CITY OF ALBUQUE

Planning Department
Allen Varela, Director

**Re: San Pedro Apartments – 9320 San Pedro Dr. NE
Erosion and Sediment Control Plan
Engineer's Stamp Date 10/11/2022 (C18E108)**

GTA SAN PEDRO, LLC
SAN PEDRO APARTMENTS
TESCP

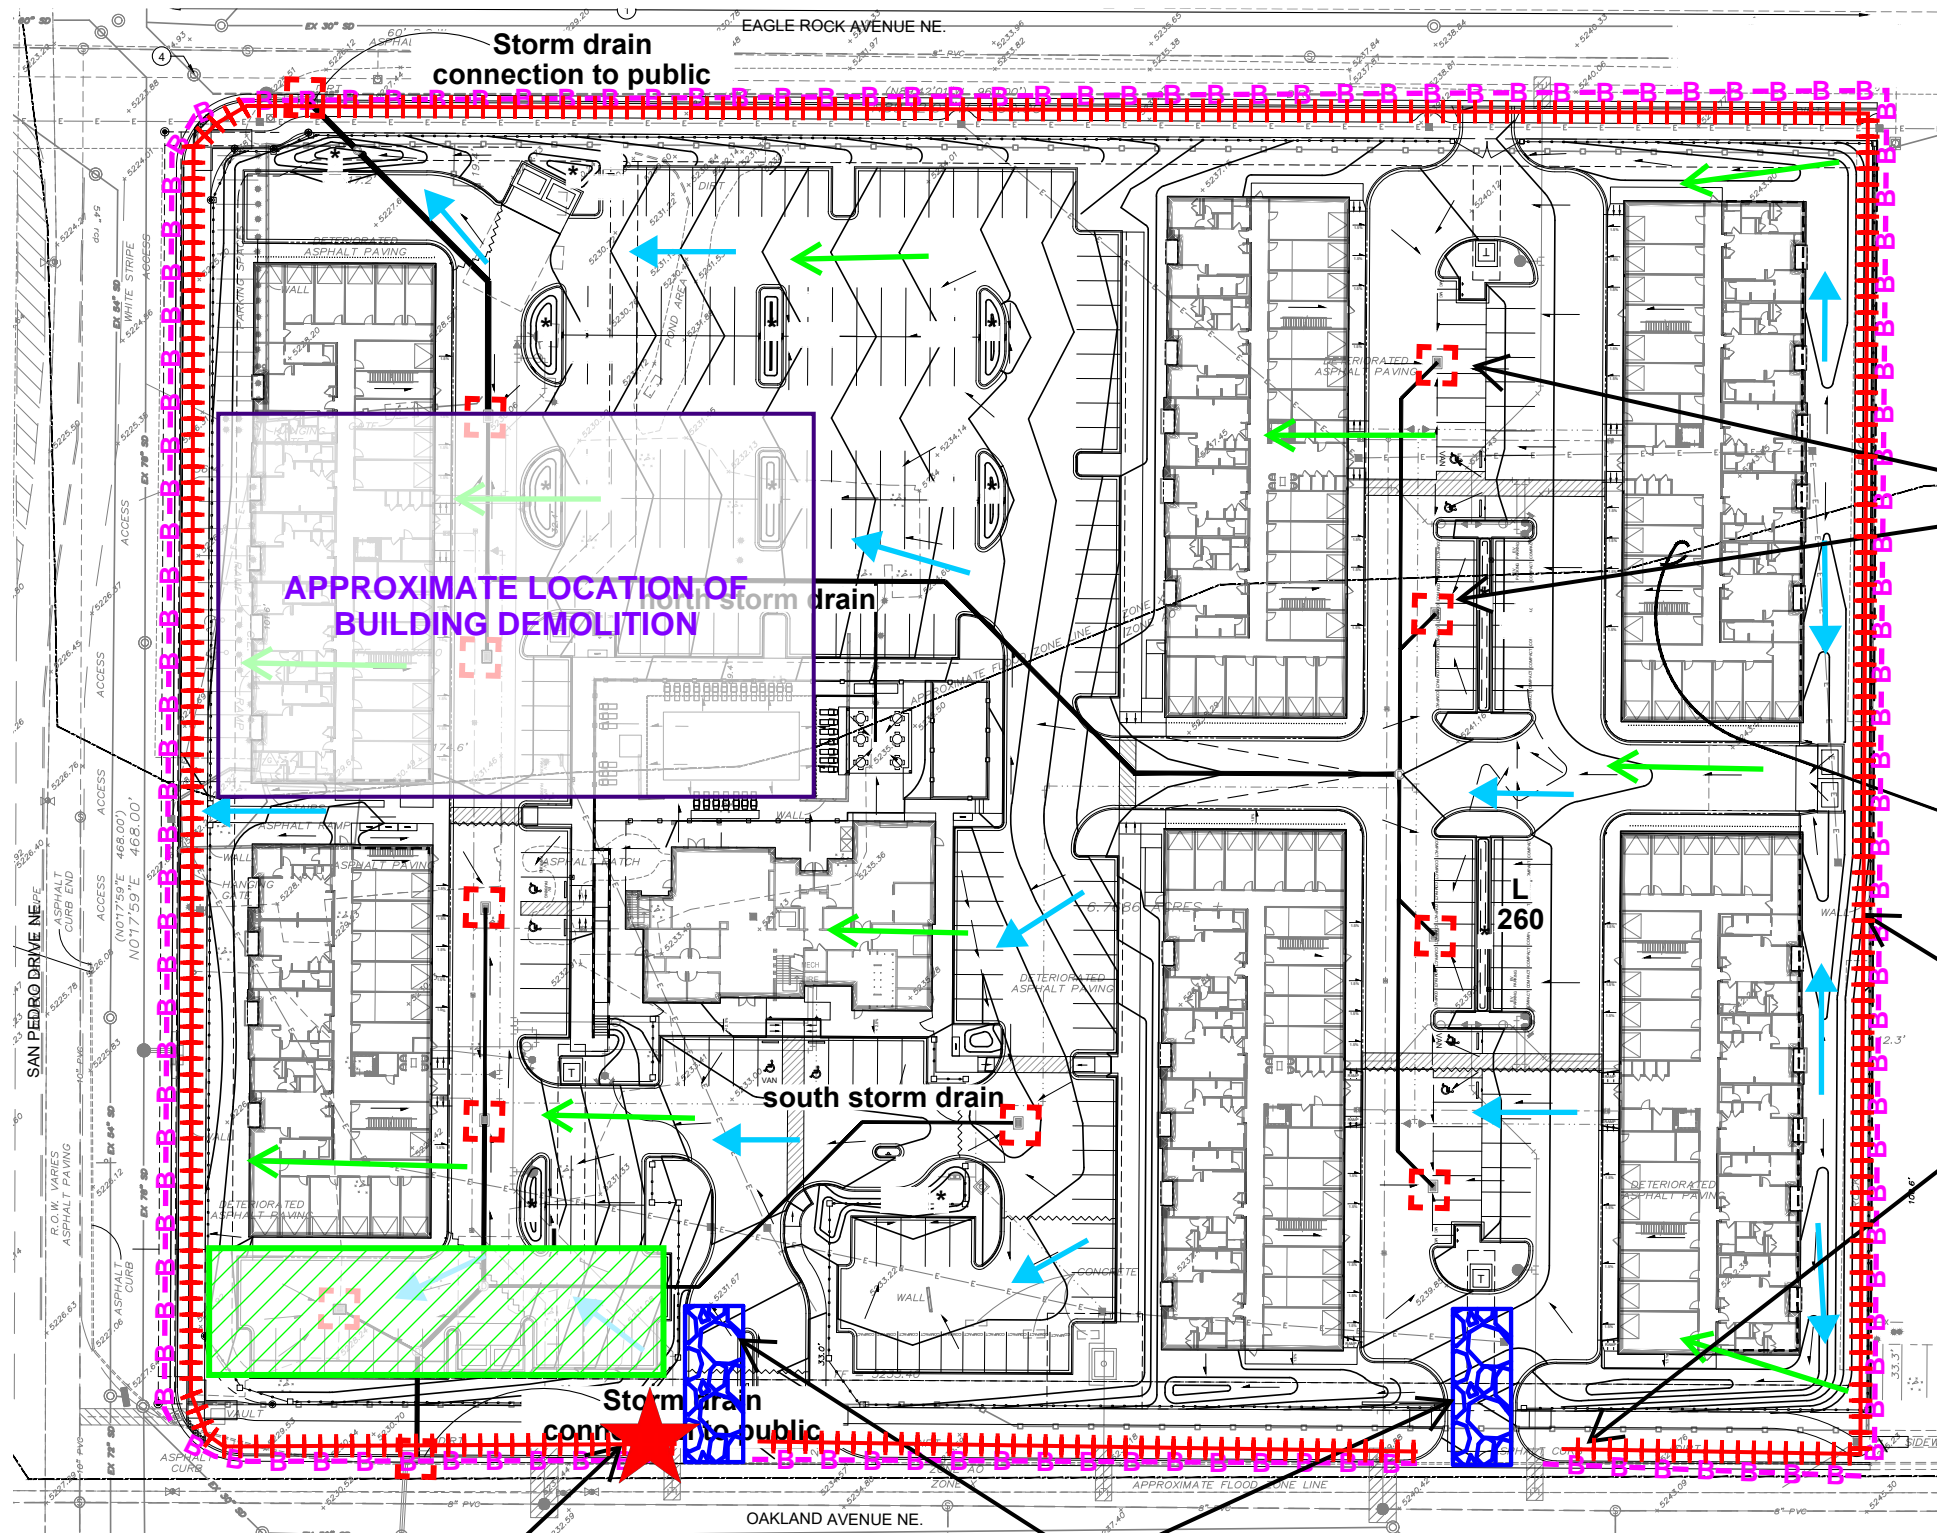
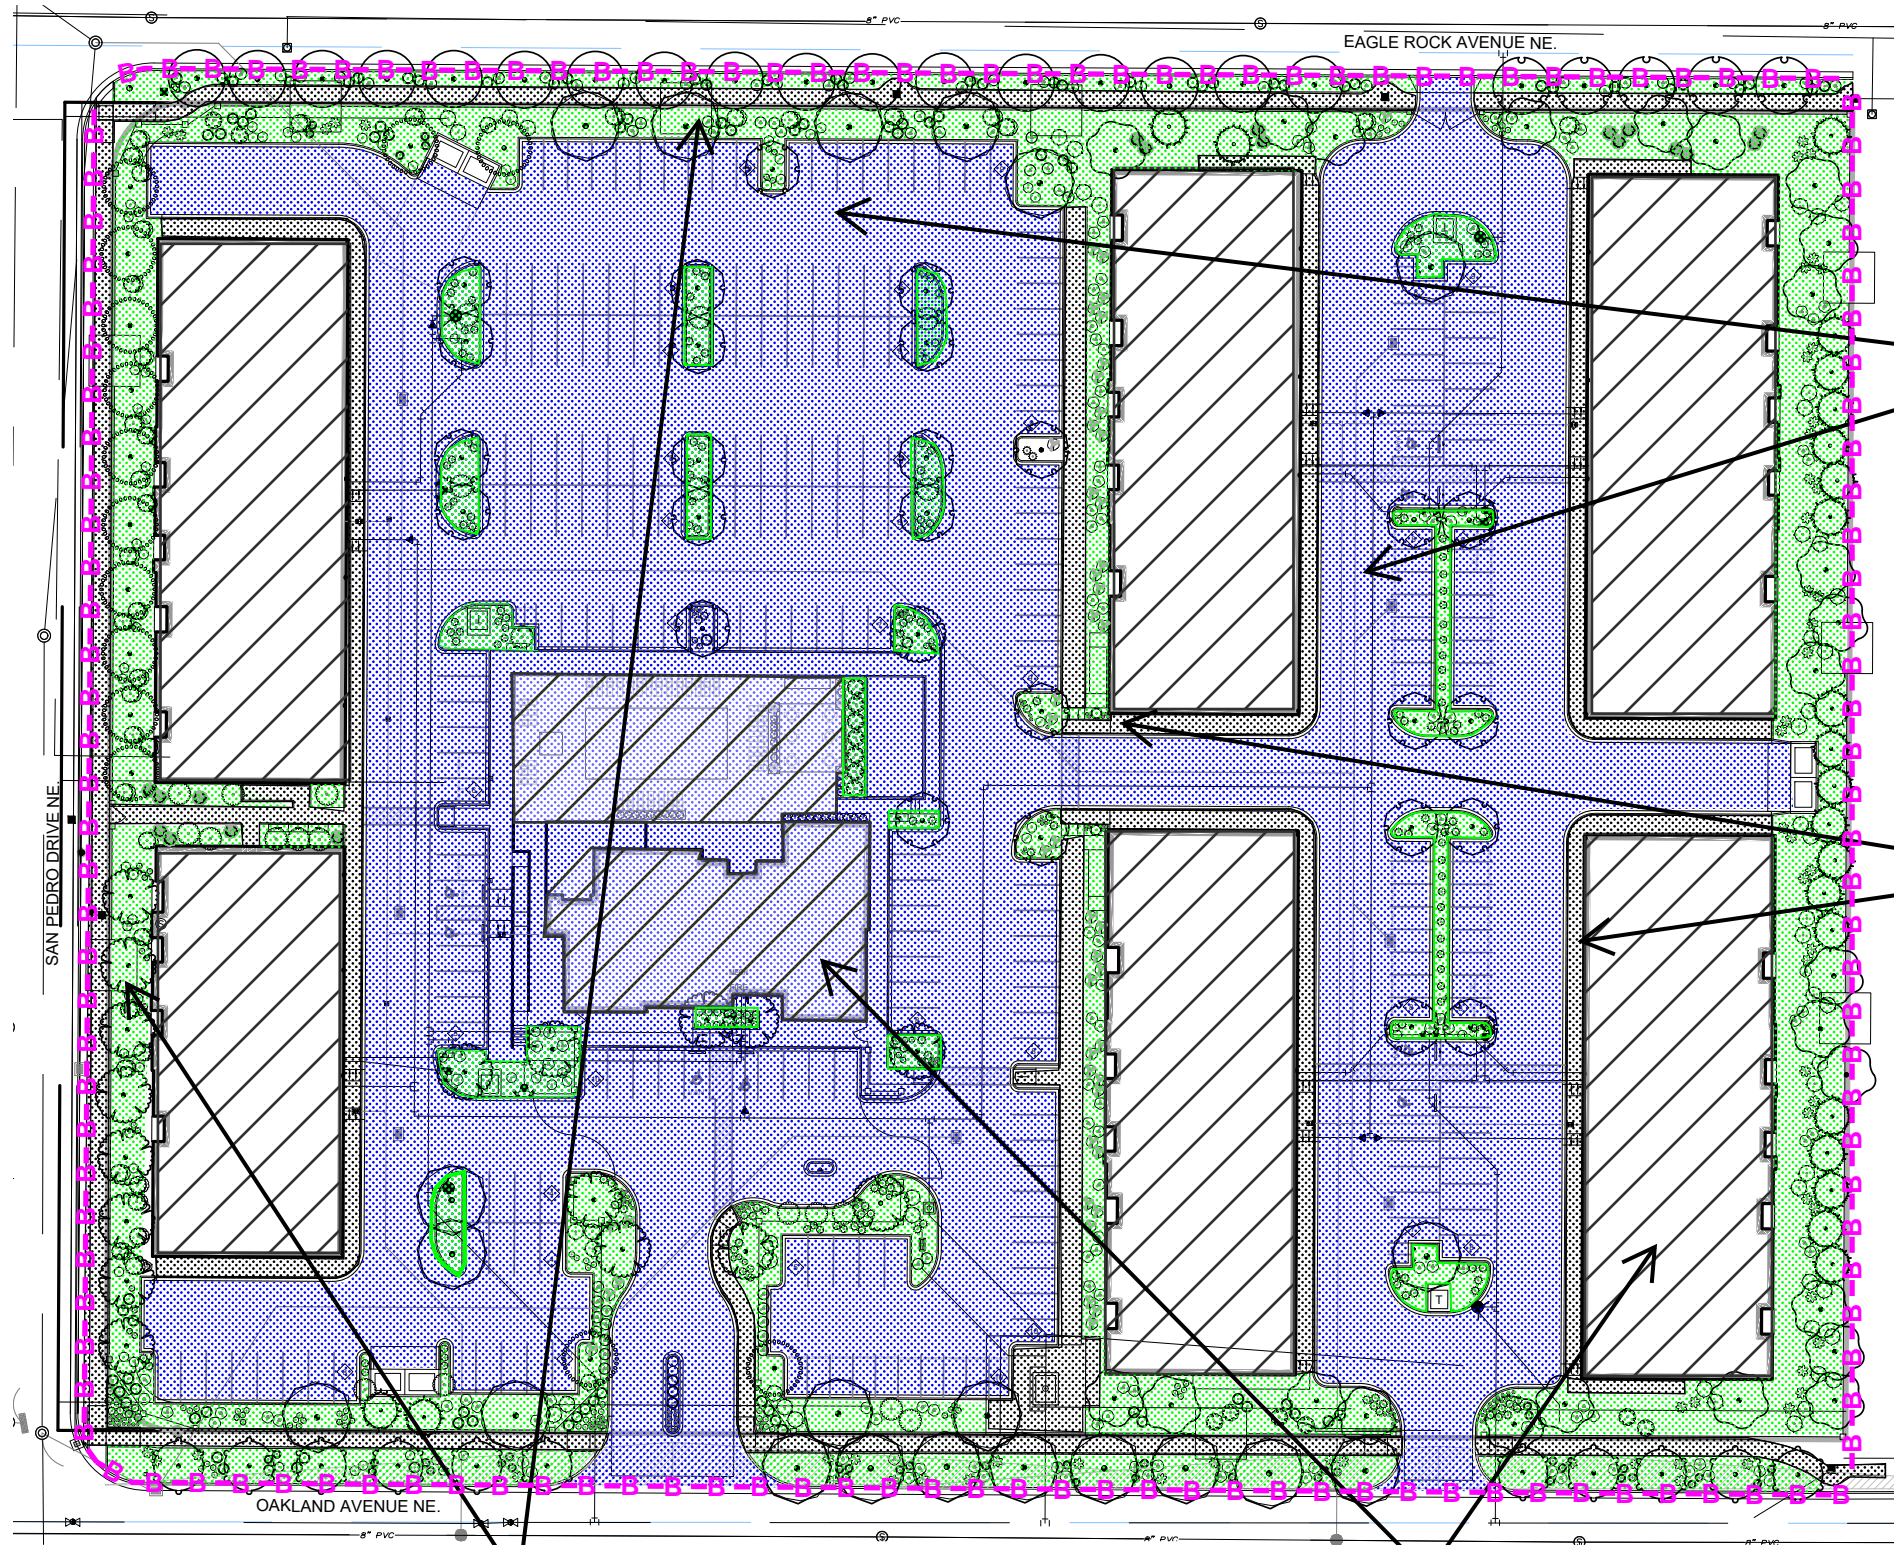
Based upon the information provided in your submittal received 11/8/2022, the above referenced ESC Plan is conditionally approved to be included in the SWPPP, Work Order, and Building Permit Plans provided that additional controls are added for the paving north and west of this site.
